re: Geotechnical Response to City Comments
 Proposed Commercial Building
 2 Bill Leathem Drive - Ottawa

date: September 25, 2020

file: PG5257-MEMO.01 Revision 1

Scale:	1:300	Project Number:	CP-20-0023
Drawn By:	N.B.V.		
Checked By:	T.D.F.	Drawing Number:	C101
Designed By:	C.J.M.

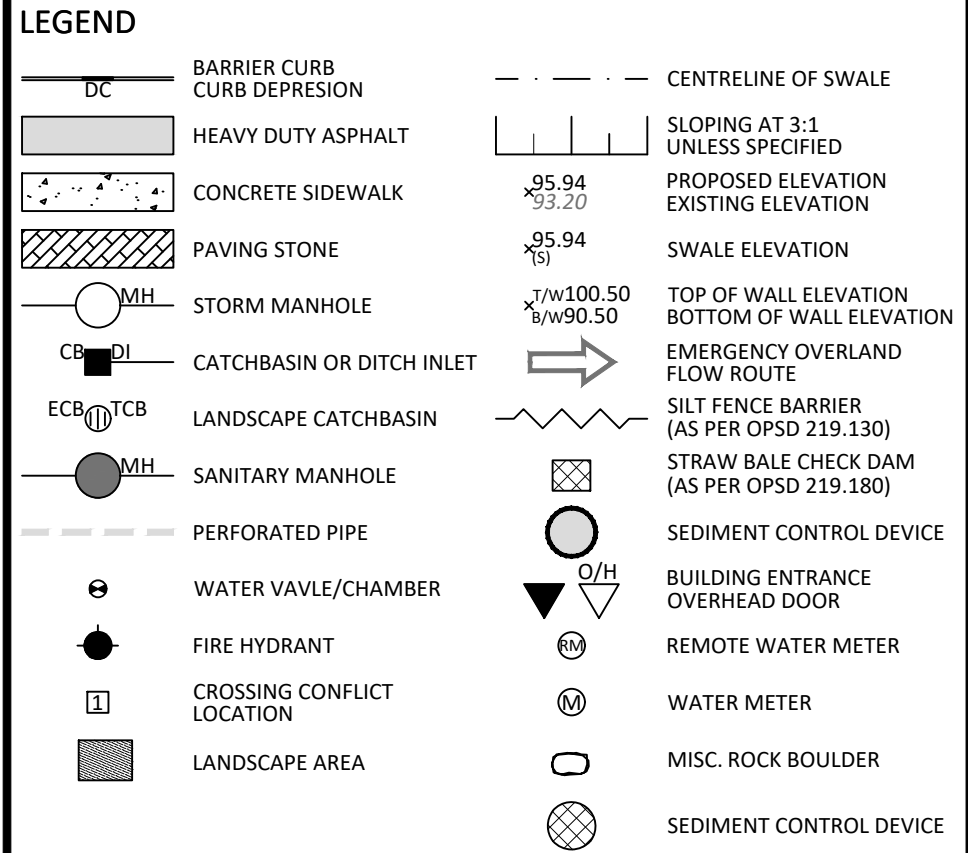
Comment 1.10: *Provide recommendations for the stormwater pond and lining requirements.*

Response: The long term performance of the proposed SWMP will depend on the stability of its excavation side slopes. It is recommended that the excavation side slopes be maintained at a minimum of 3H:1V.

Upon reviewing the grading plan provided by McIntosh Perry (Revision 2, dated August 6, 2020), the slopes surrounding the proposed pond are proposed to be shaped between 3H:1V and 4H:1V which is considered acceptable from a geotechnical perspective. The bottom of the pond is designed at an elevation of 89.5 m with the 100-year water level of 89.96 m.

Based on our findings in the borehole locations drilled within the SWMP immediate area, the bottom of the pond is expected to consist of a brown, non permeable silty clay deposit. Therefore, a clay liner will not be required for the subject pond.
